Application No: LU/320/20/DOC

Site Address: Land south of Cornfield Close Littlehampton BN17 6LD

Description of Works: Approval of details reserved by condition imposed under ref LU/330/18/PL relating to Condition Nos 4 - energy supply and 19 - provision of facilities for the unequipped Local Area for play.

Scheme No: 21198rev2/WSU Date: 28/05/2020 Drawn by: RG/KT Scale: 1:200

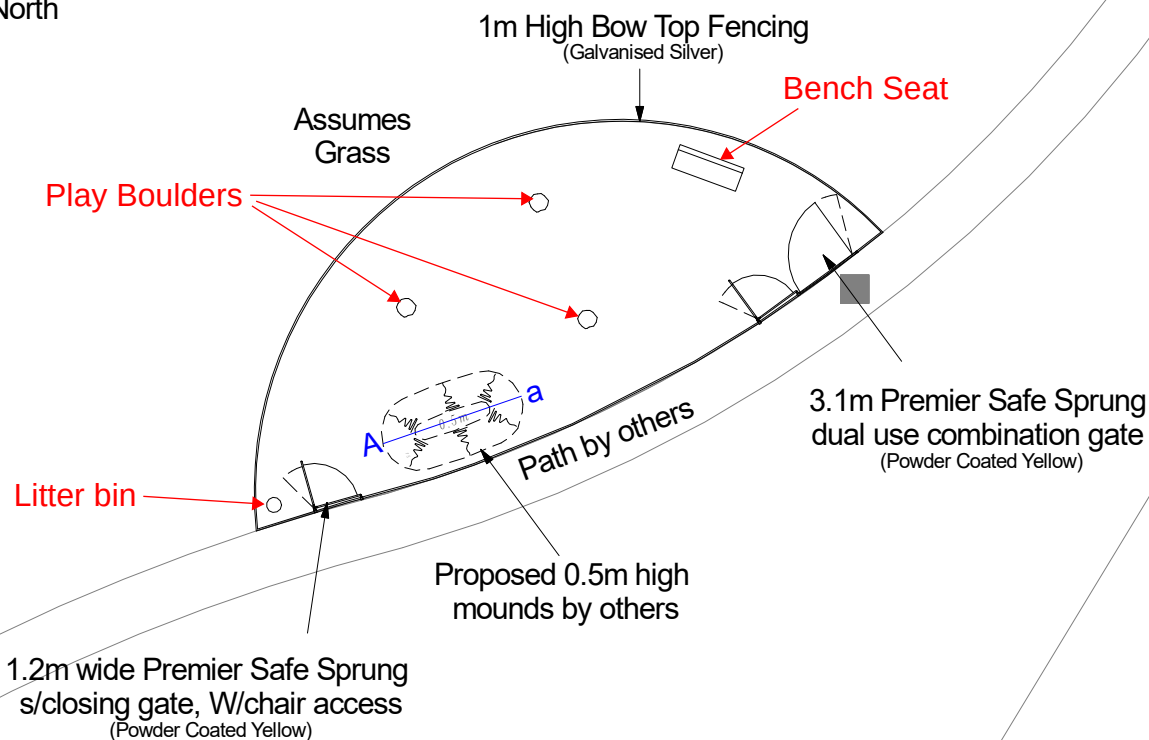
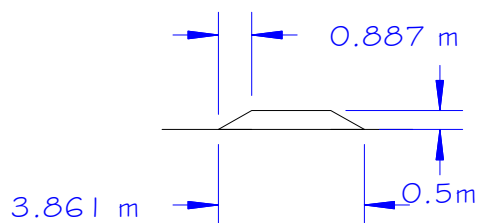
I'm pleased to see that the drawing that was posted to the portal yesterday (dwg 21198 rev 2/WSU) has given a bit more clarity re what the LAP is to contain ie the boulders now annotated.

My comment would have been that I think in this situation a fully bow top fenced and gated area is a bit obtrusive, an expensive option for little aesthetic and user gain. In this case a more natural LAP would have been preferred with no fencing, possibly just a knee rail section along the pathway, further mounding on three sides and possibly some associated planting in blocks rather than the fenced and gated LAP that is being proposed. The glacial boulders seat and litter bin would still be fine for location.

I appreciate that condition 19 may have now been discharged, but thought worth just commenting in case there is any possibility still for this to be amended. If it is too late to request amendment, then what they have proposed would be fit for purpose (just not aesthetically) and could be implemented.
